Application Ref: H02-0033-26

Proposal: **Construction of new detached dwelling**

Location: **Land to rear of 53 West Street, Crowland, Peterborough, PE6 0EE**

ADDITIONAL INFORMATION REQUIRED

Drawing Title:  
Proposed Plans  
Elevations & Site Section

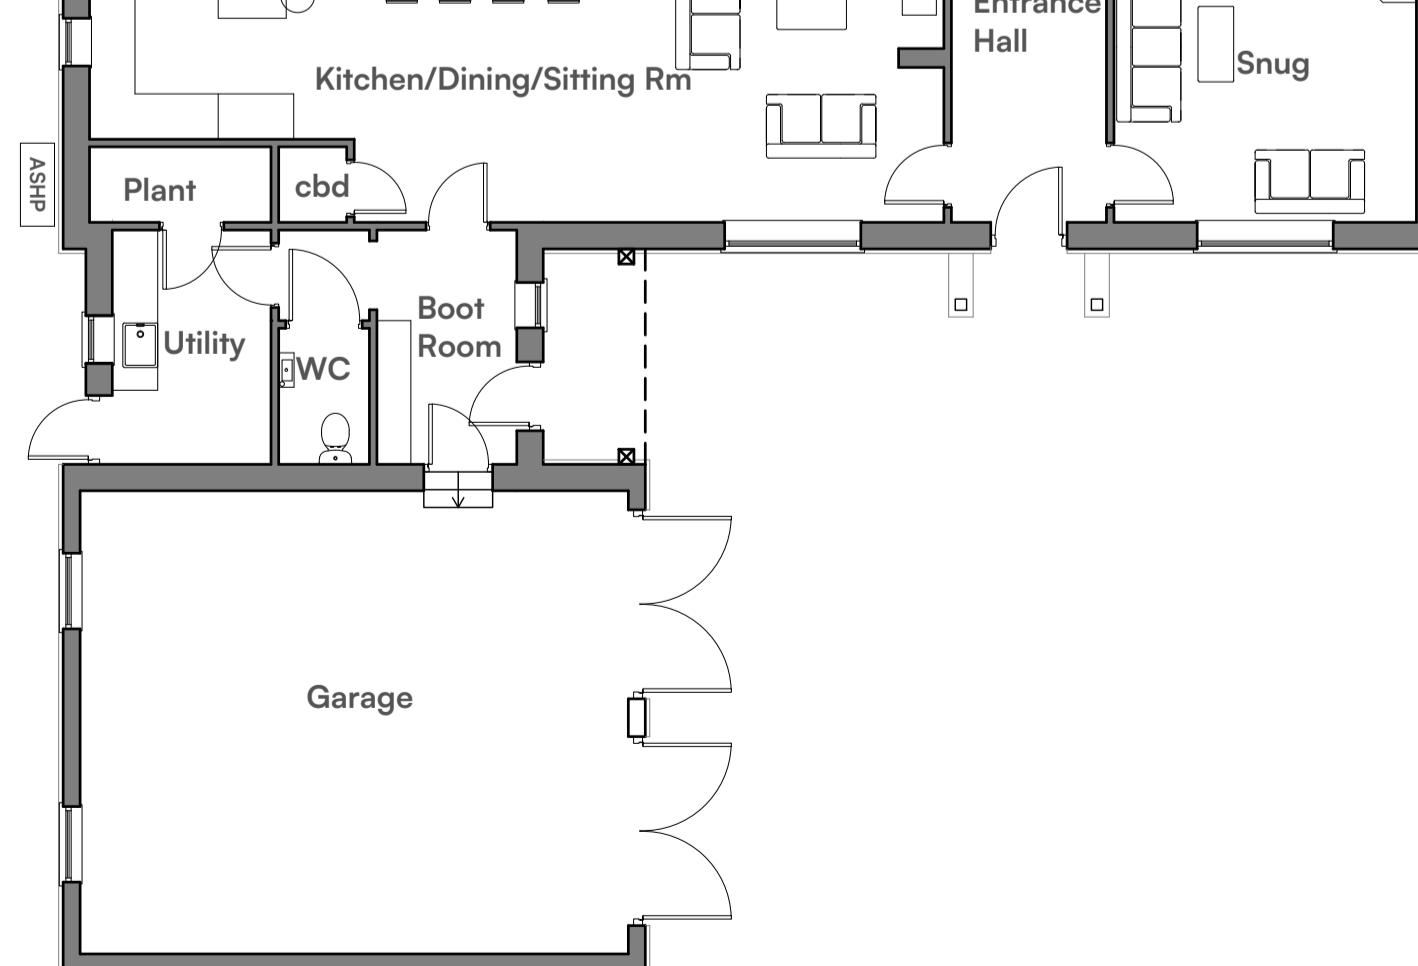
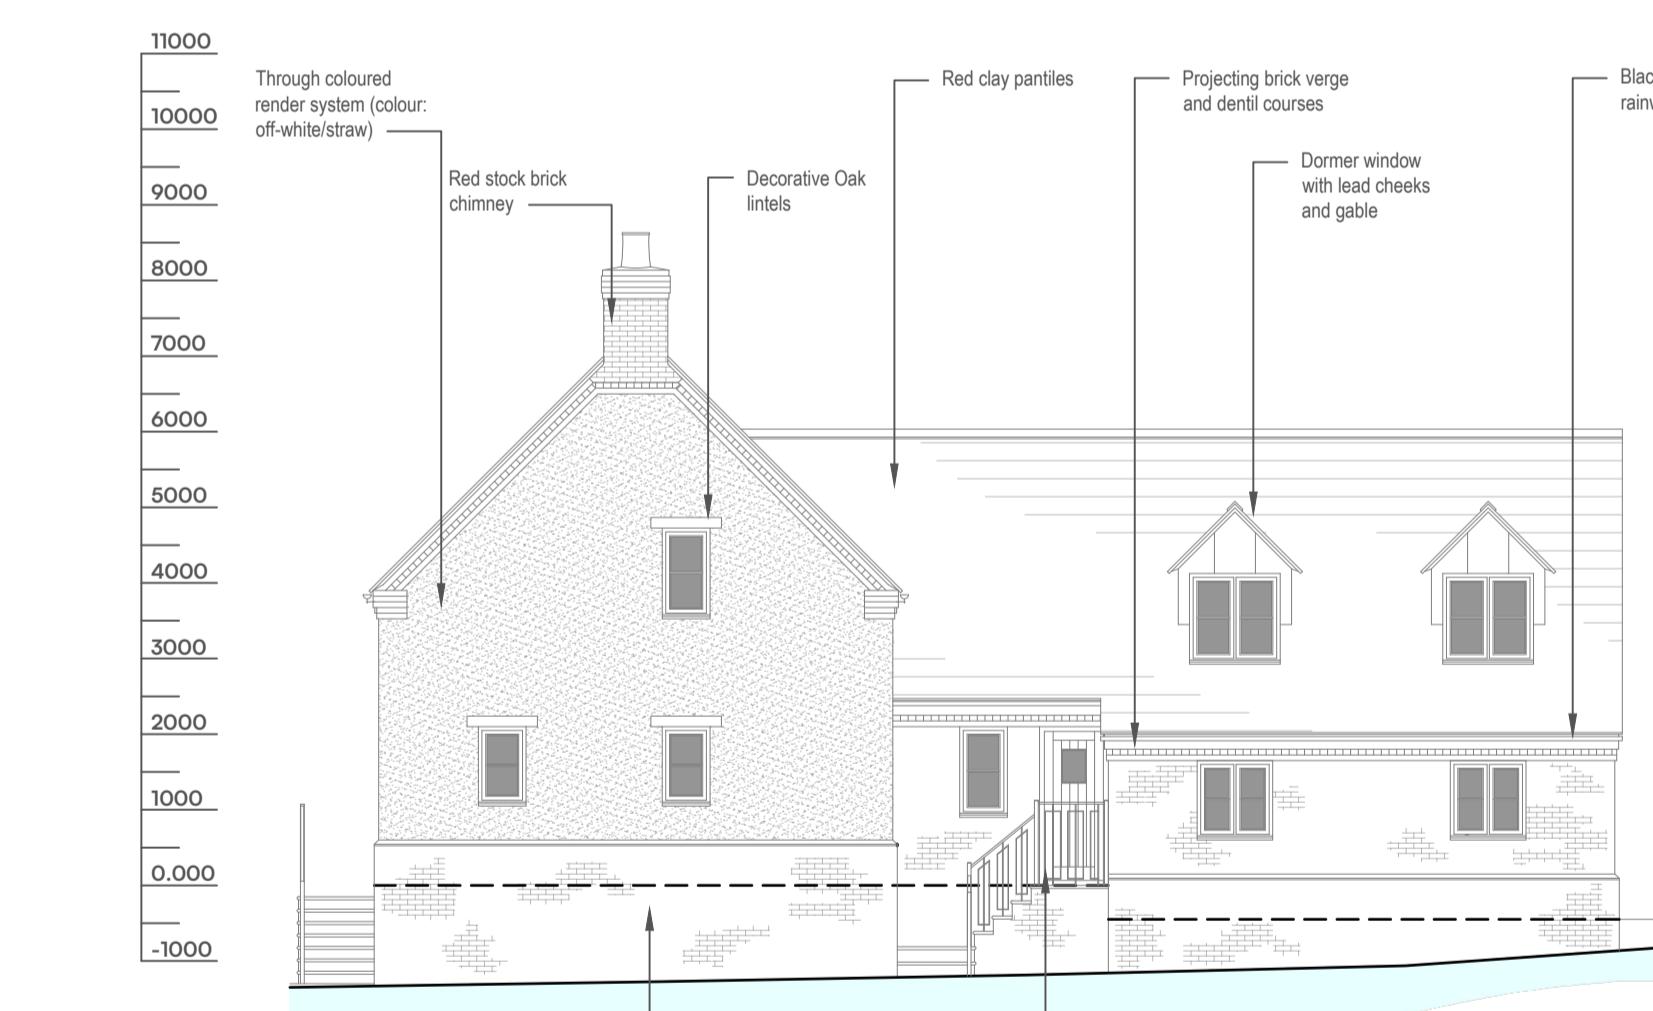
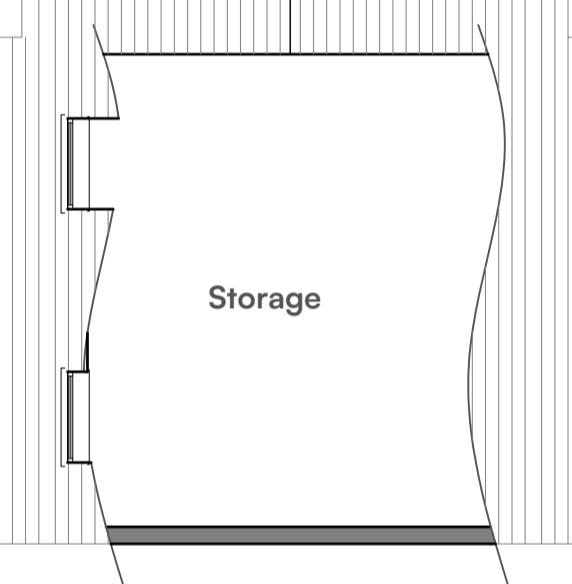
The access shall be widened in line with Lincolnshire County Council Specification, and a note should be added to the proposed site plan.

The dimensions of the garage should be detailed. To be able to accommodate a parked vehicle it should measure 3m x 6m or 6m x 6m for a double garage.

The host dwelling currently has space in which they can turn to enter and leave the site in a forward gear – this design removes that facility. Please include a turning facility in the design for the host dwelling.

How many bedrooms does the host dwelling have? A dwelling with three bedrooms or less should have two parking spaces, a dwelling with four bedrooms or more should have three parking spaces.
